Our Ref: R/190/18/PL

**Town & Country Planning Act 1990 (as amended)
Town and Country Planning (Development Management Procedure) (England) Order 2015
Application for Planning Permission**

Development Demolition of 1 No. existing house & grounds & erection of 2 No. new detached dwellings. This application may affect the character & appearance of the Station Road, East Preston Conservation Area.

Location St Marys Close Hurst Road Rustington

Drawing Title:
ADDITIONAL DWELLING
plots 1 & 2
FLOOR PLANS

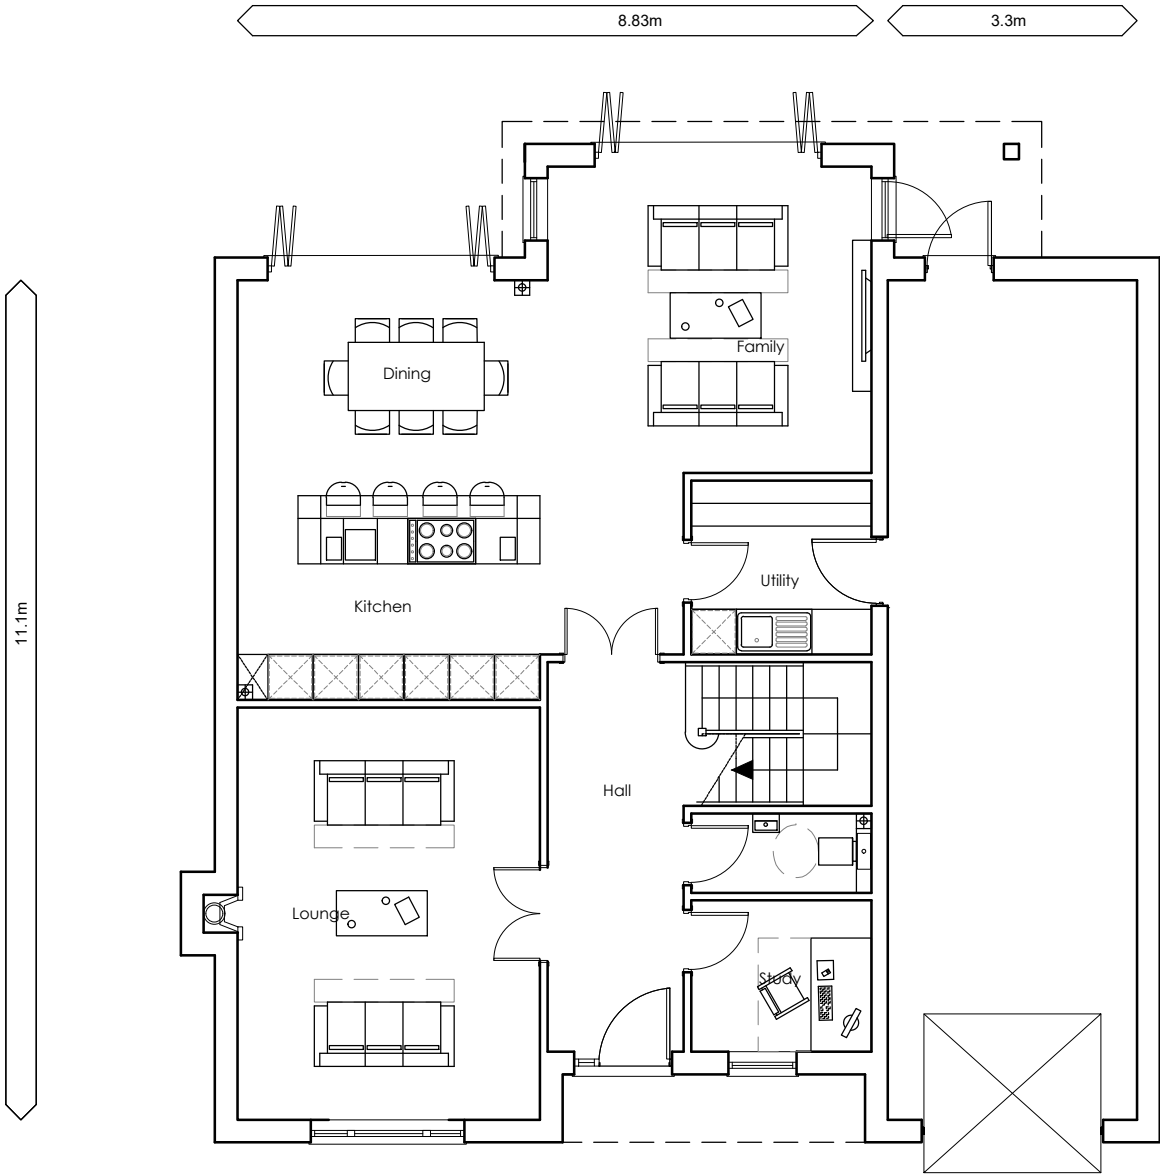
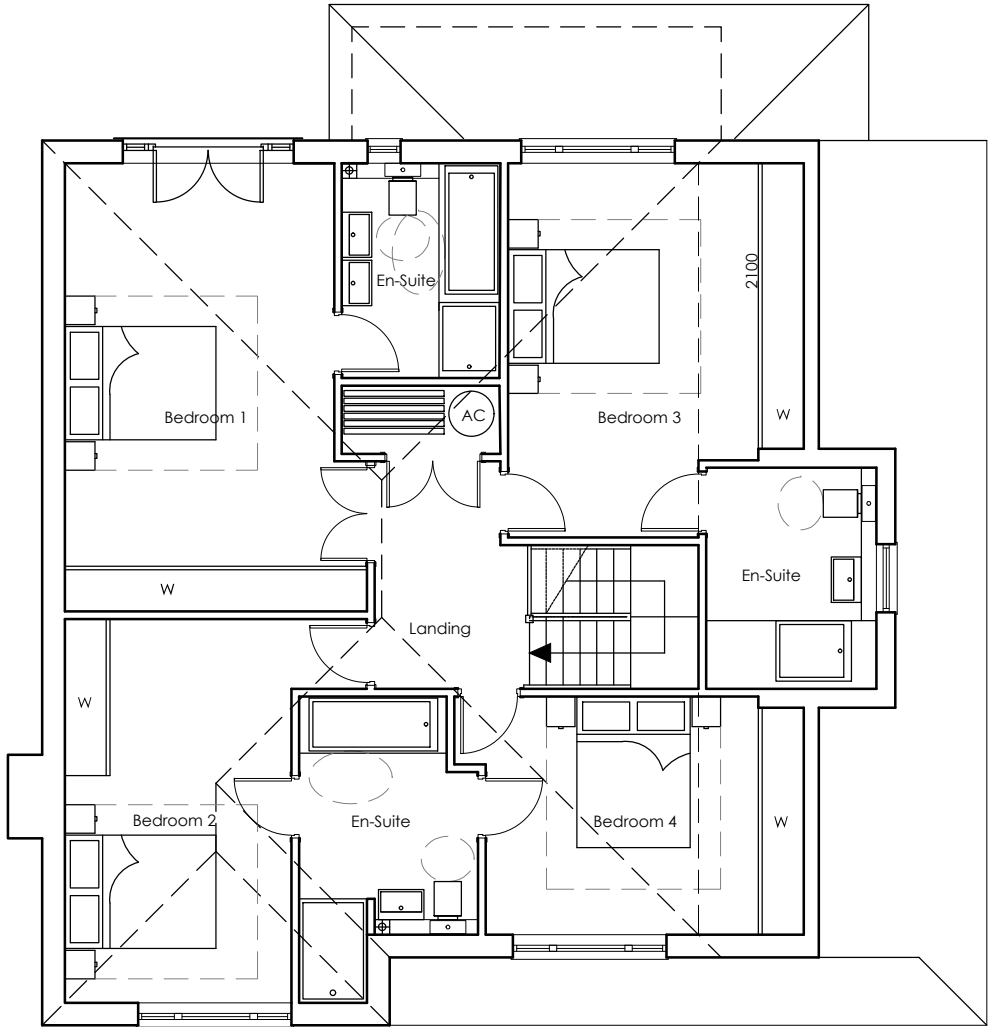
The proposed east and west floor plans and elevations do not accord. Please amend accordingly.

Please confirm that both houses are the same (as only one set of floor plans and elevations have been provided).
